Arun District Council
Arun Civic Centre
Maltravers Road
Littlehampton
West Sussex BN17 5LF
Planning & Building Control General Enquiries
Tel: (01903) 737756 Fax: (01903) 730442
Dx: 57406 Littlehampton
Minicom: 01903 732765
e-mail: planning@arun.gov.uk
website: www.arun.gov.uk/planning

Application No: AB/98/21/HH
Site Address: 4 High Ridge Close Arundel BN18 9ES
Description of works: Erection of 2No single storey rear extensions. Conversion of roof space to habitable use to include 2No front and 1No rear flat roof dormers. Increased width of existing vehicular crossover and 1No additional crossover. Gabled canopy to front entrance and removal of chimney.

OWPC40533

Roof space plan 1:100 @ A3

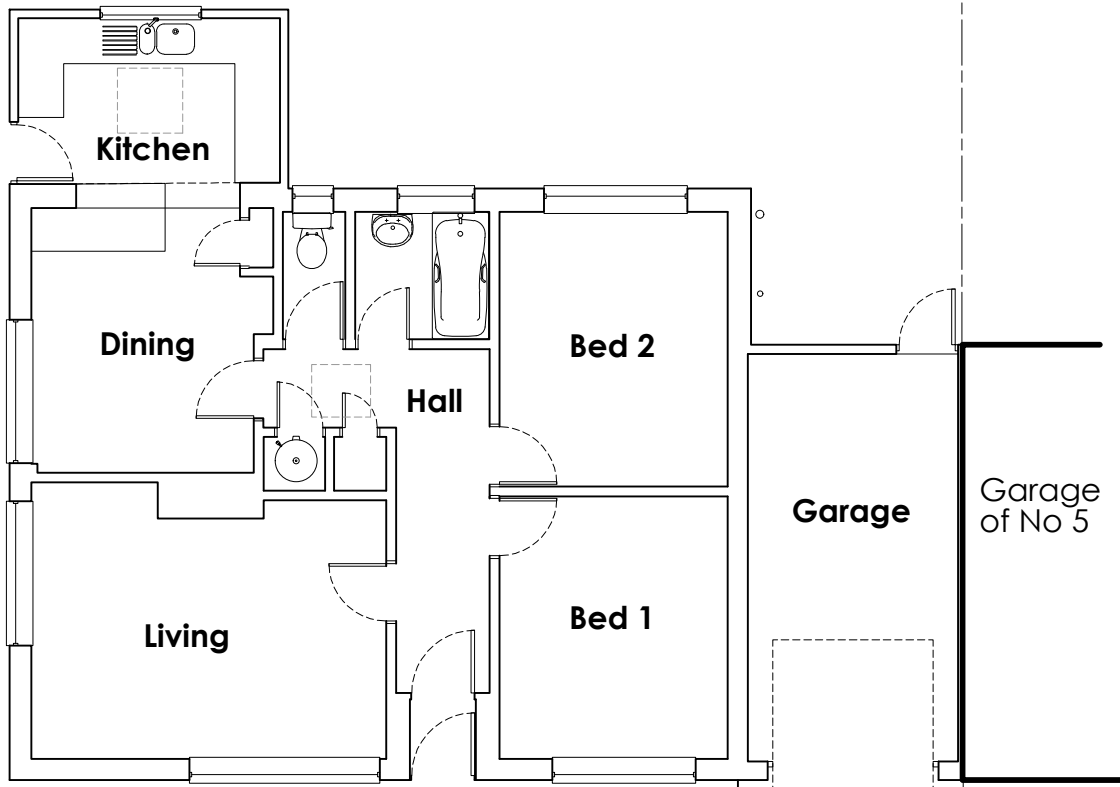
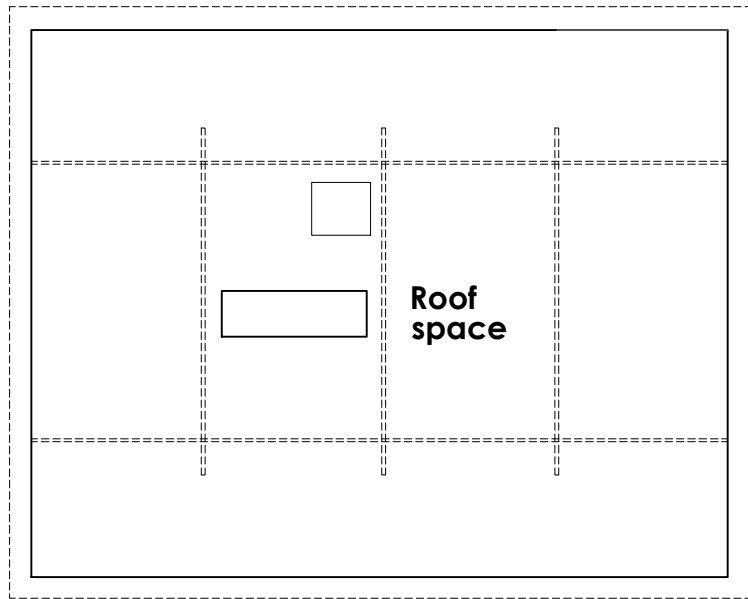
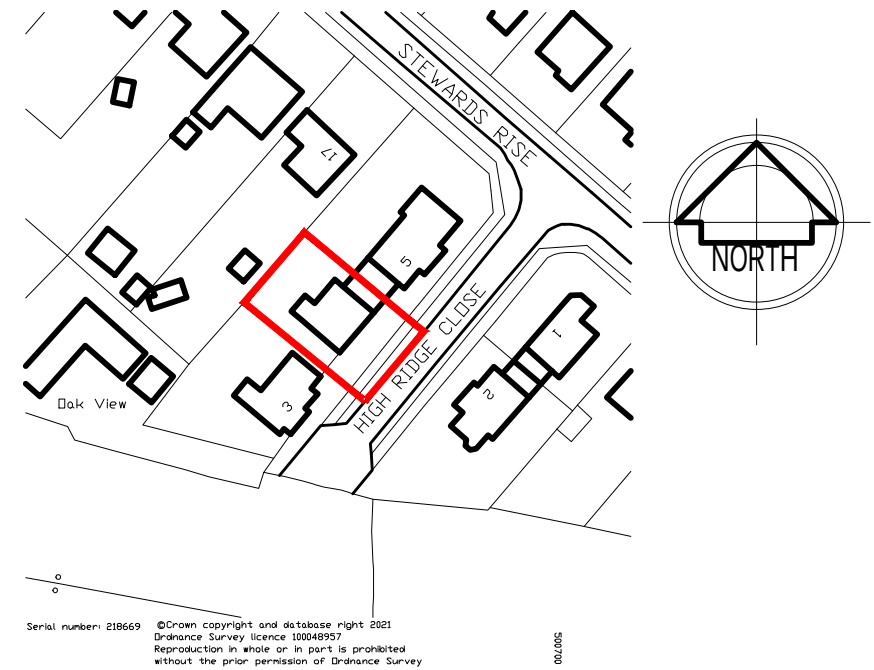
The Committee objected to the Application on the grounds that the proposal does not meet the requirements in sections M01 and DM4 of the Arun Local Plan.

Section M01: 'Overdominant compositions should be avoided by ensuring that designs are a minor incident in the roof plane and made of sympathetic to the existing or original building materials, are located symmetrically and centrally on a roof, without being overly dominant or out of proportion and/or style to the original structure, are not located close to verges or hips and have gabled or flat lead roofs, do not damage the original character and appearance of the building and its surrounding area and minimise interference to the original form, appearance and fabric of the original built structure.

Policy D DM4 When considering applications for extensions and alterations to existing buildings, the Council will require that:- The extension or alteration sympathetically relates to and is visually integrated with, the existing building in siting, massing, design, form, scale and materials.
